Y/21/19/DOC - land at North End Road, Yapton

Comments on the Phase 1 below (note 2 emails)

Further to the below comments regarding the Phase I report, please may the following also be clarified:

scale	date	job no.	ding no.	rev.
1:500 @A2	MAY 17	1706	2.10	P2

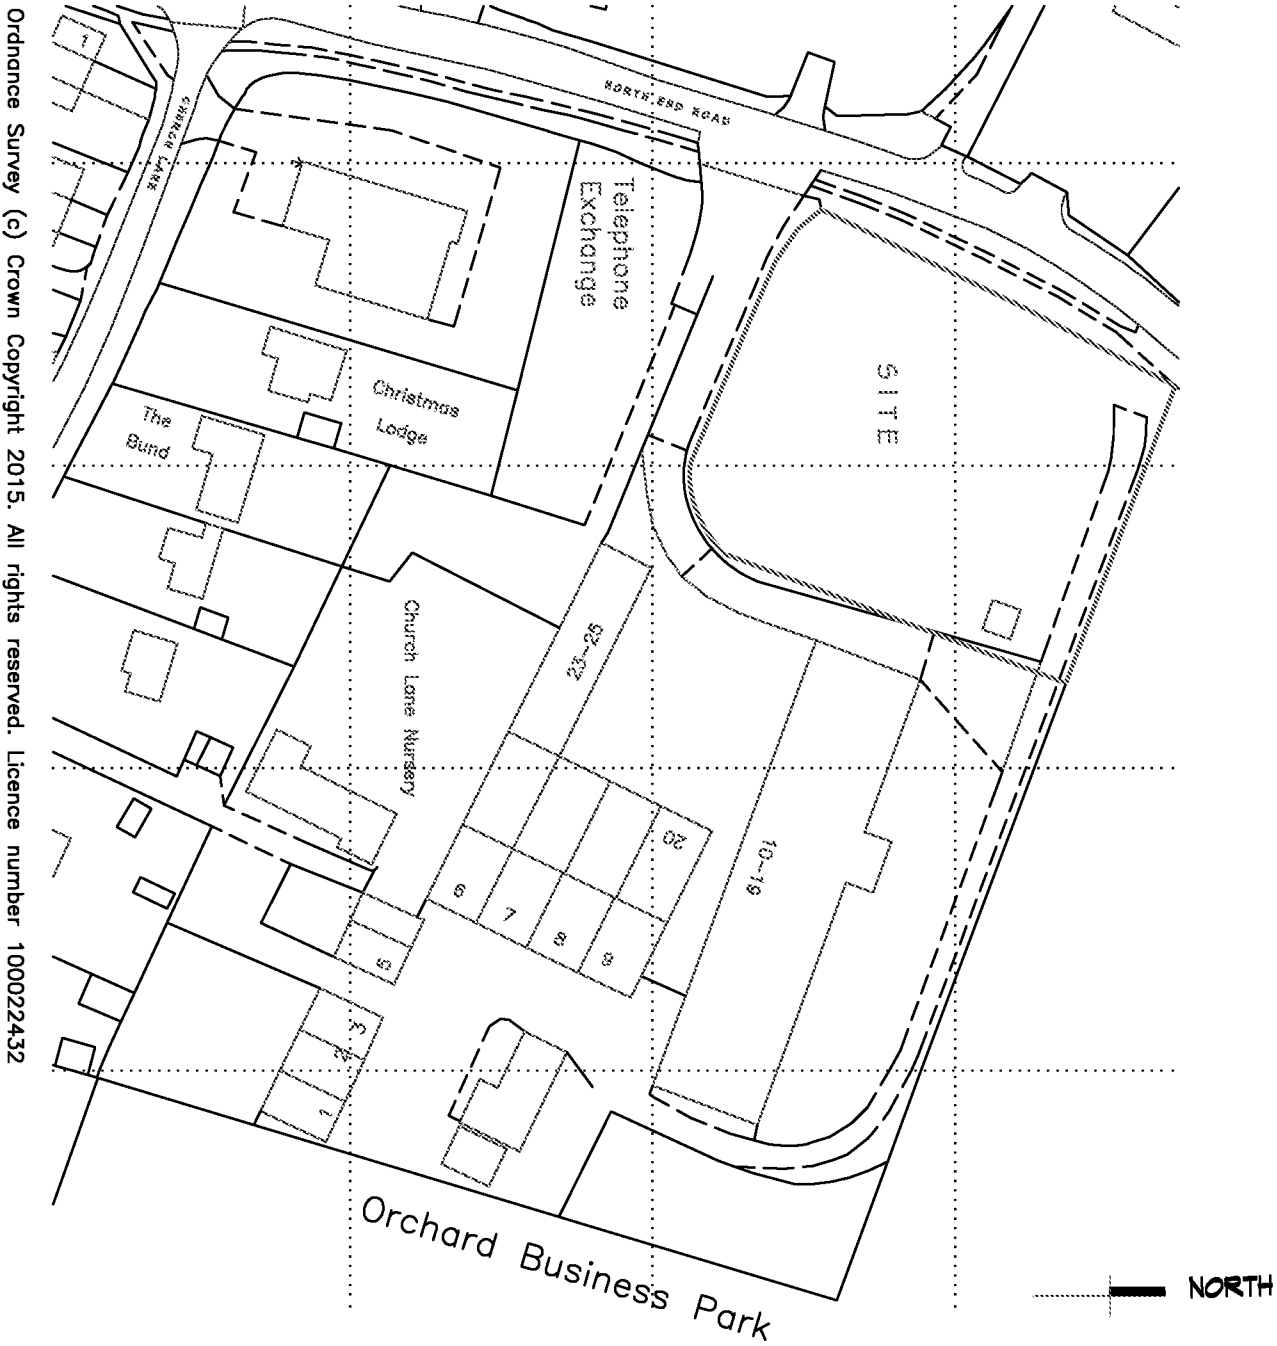
- was any ground gas monitoring conducted (and if so, I'll need to see the report, please)
- in relation to the statements that radon and UXO are unlikely to pose a risk/do not require further action, could this reasoning be qualified
- it does not appear that any testing for PCBs was undertaken
- could the locations of the sampling points (only the ones relating to potentially contaminated land) be provided in relation to the proposed site layout as it not clear when comparing the two diagrams
